**Re: DART+ South West Electrified Heavy Railway Order - Hazelhatch & Celbridge Station to Heuston Station, and Hesuton Station to Glasnevin
County Dublin and County Kildare**

From: Dermot Foley
Sent: Tuesday 16 May 2023 15:57
To: SIDS
Cc: sinead langan
Subject: DART+South West Electrified Railway Order 2023

Re: Application by CIE for a Railway Order for the DART+South West Electrified Heavy Railway (2023)

Project Title	DART + SOUTH WEST		
Drawing Title	EARTHWORKS STANDARD DETAILS SHEET 2		
Drawing File Name	DP-04-23-DWG-RO-TTA-18961	Version	v01
Status	S3

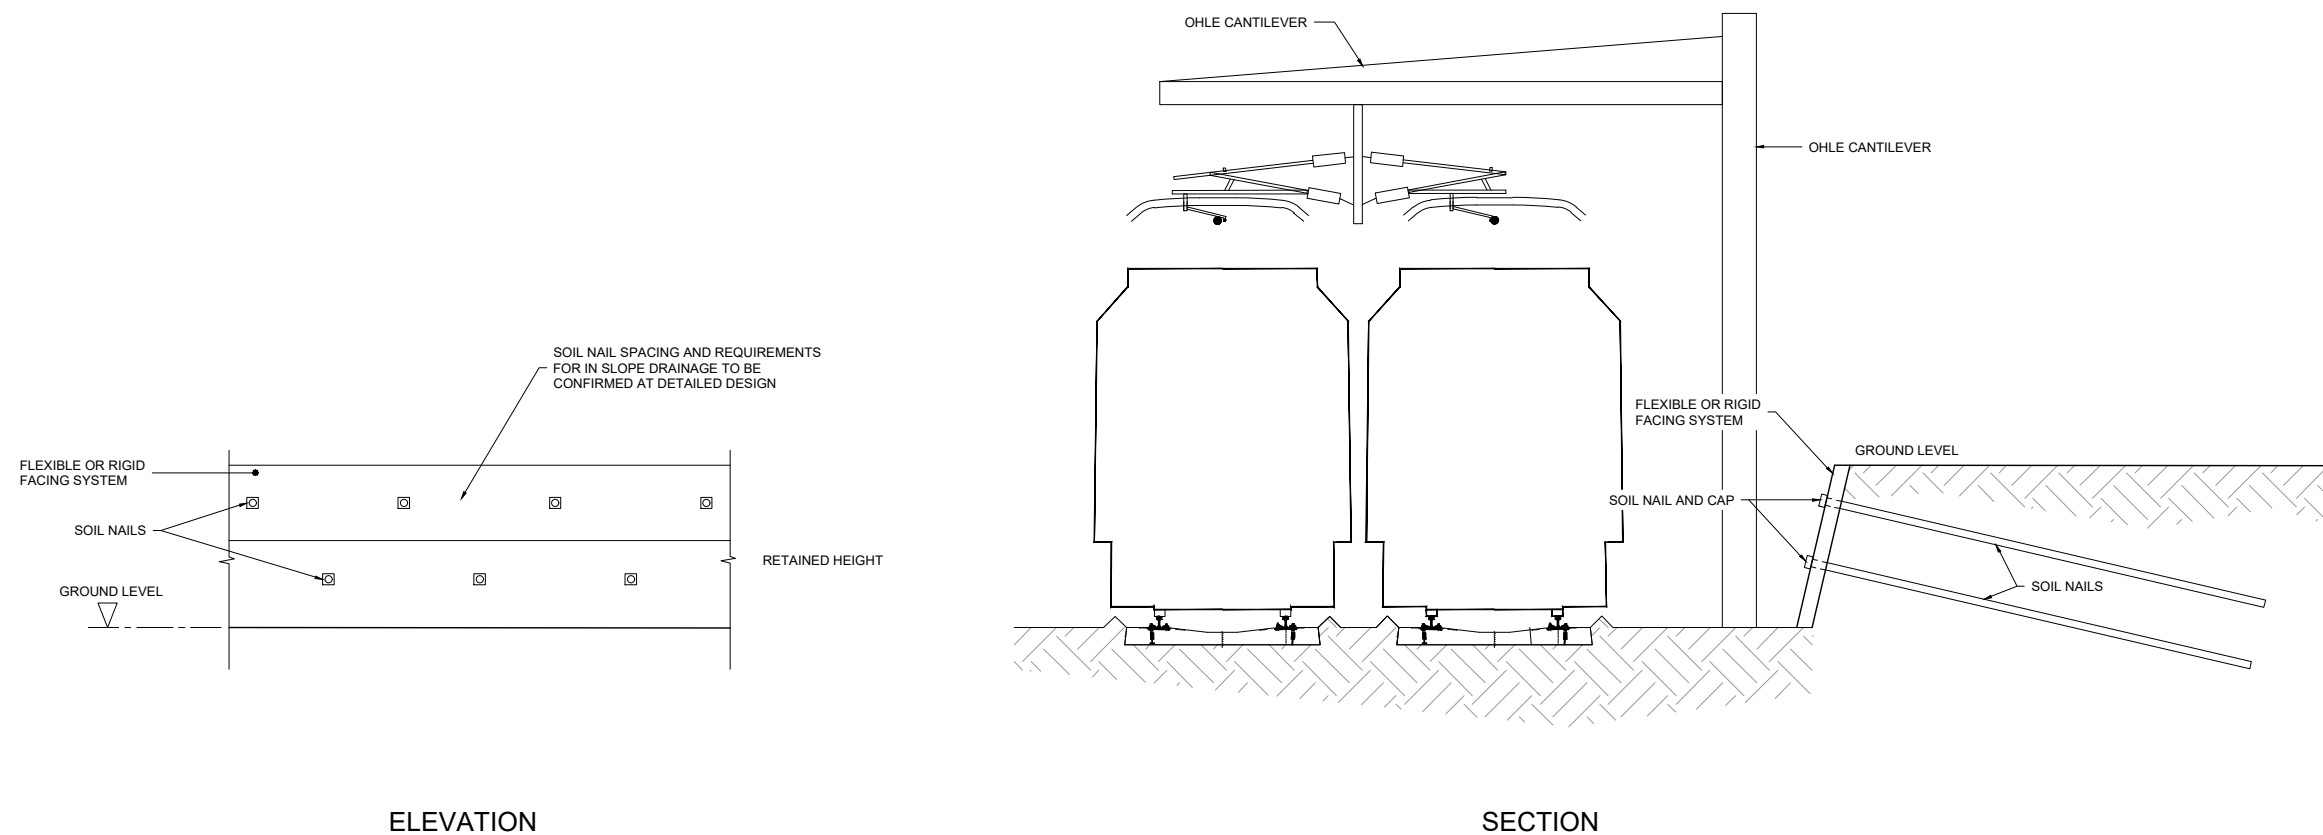
The document 'Zone B-Park West-to-Heuston-Station.pf' refers on page 15 (Earthworks Sheet 2) to a Wayleave crossing our property, but it is not clear as to whether this is intended as a wayleave during the limited period when works will occur adjacent to our property or if there are any long-term implications. We request more details on the nature and duration of the proposed wayleave.
